Office of
Environment
& Heritage

DOC 18/451298-2
SSD 8989

OEH Review of Environmental Impact Statement: Catherine McAuley Catholic College (SSD 8989) - 507 Medowie Road, Medowie – Port Stephens LGA

Title:  
**Proposed Site Plan and Flood Hazard Categories**

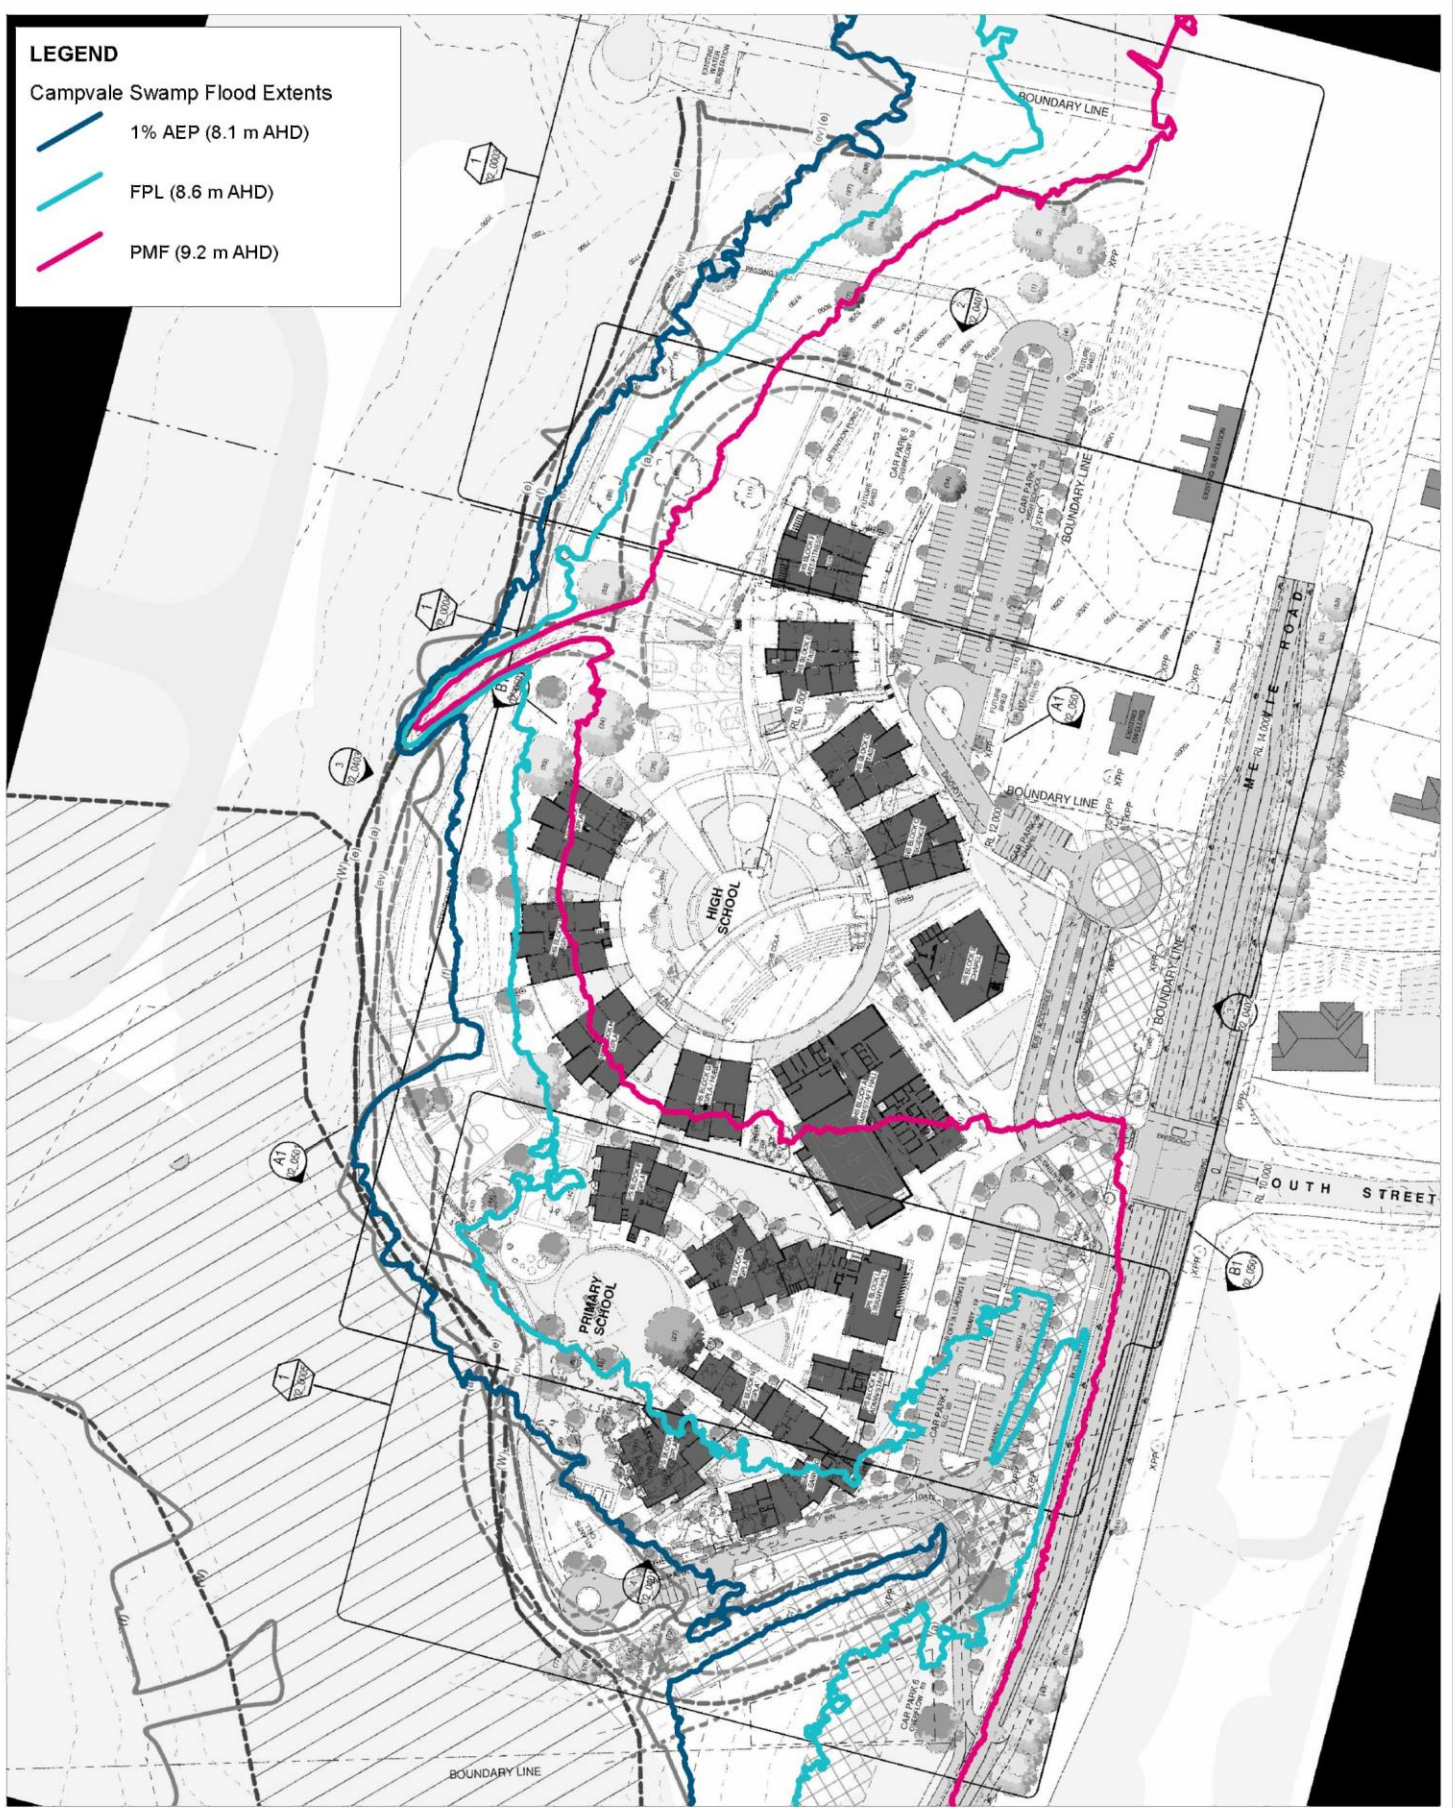
The proposal has the potential to divert high hazard flows along the side of a proposed primary school building. OEH has reviewed the flood assessment provided by BMT. Figure 2 shows a proposed access road traverses a high hazard floodway. This crossing, if not properly designed, has the potential to capture and divert hazardous flows towards the proposed primary school.

OEH recommends that the proponent provides design details and a flood assessment of the access road creek crossing, demonstrating that there will be no adverse flood impacts.
